From: Biazar, Shahab
Sent: Saturday, December 12, 2015 4:43 PM
To: Yolanda Padilla Moyer; Kevin G. Patton (kevin.patton@pultegroup.com)
Cc: Abiel X. Carrillo (acarrillo@cabq.gov); Elliott, Stanice (staniceelliott@cabq.gov); Harmon Rita T. (rharmon@cabq.gov)
Subject: Pulte @ Mirehaven Grading and Drainage Plan (H09D017E)

The following are my comments based on my review of the latest grading and drainage submittal for Pulte @ Mirehaven Phase 2 (overall and the phasing grading plan):

PULTE @ MIREHAVEN PHASE 2
OVERALL GRADING PLAN

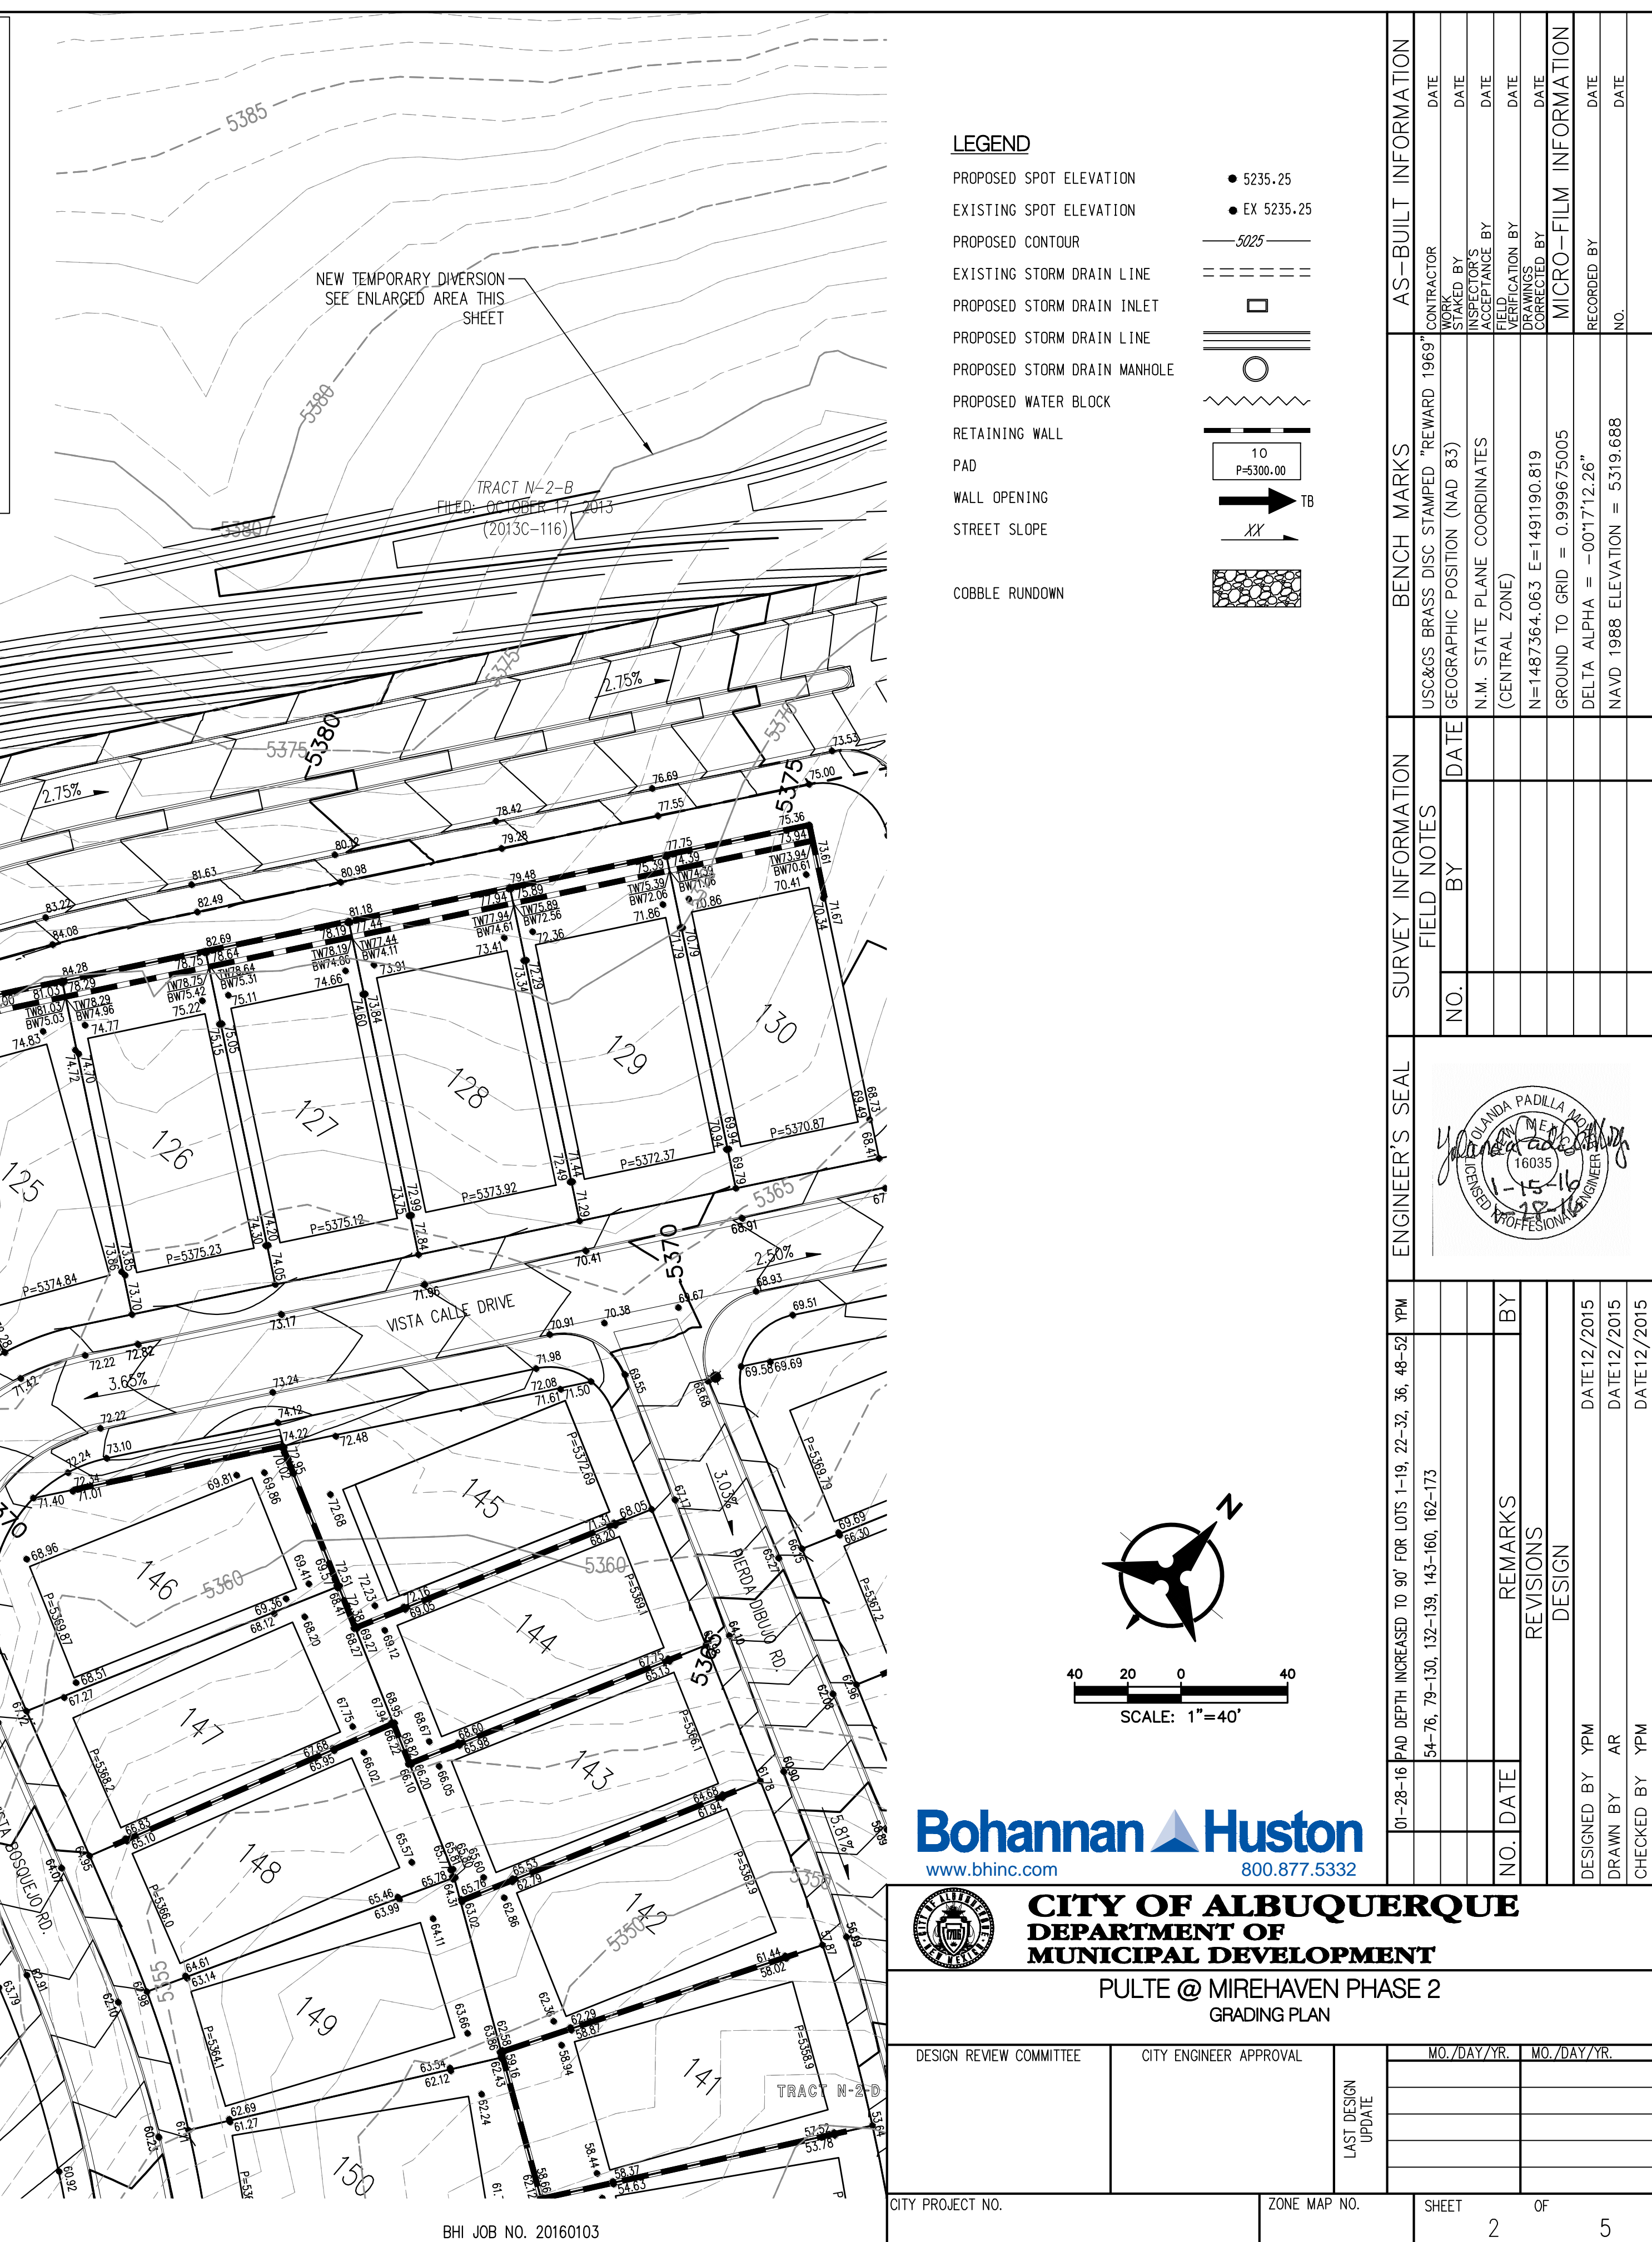
- Please provide drainage easement and maintenance responsibility over Tract N-2-E-3.
- Fix the grades around Lot 20.
- Additional runoff (6 cfs) will drain down Abo Canyon to exiting storm drain system. How this will impact the street flow capacity and the storm drain infrastructure?
- Provide drainage capacity calculations for the proposed swales shown on Sections A-A and B-B.
- Will the 20 cfs north of lot 86 drain to a first flush pond? How the downstream storm drain system will be impacted? Please provide first flush ponding calculations.
- Please provide first flush ponding solution/details/calculations for front part of the pads.
- Maintenance and covenant must be provided for all the storm structures maintained privately.
- An Erosion and Sediment Control Plan must be submitted and approved prior to grading of the site.
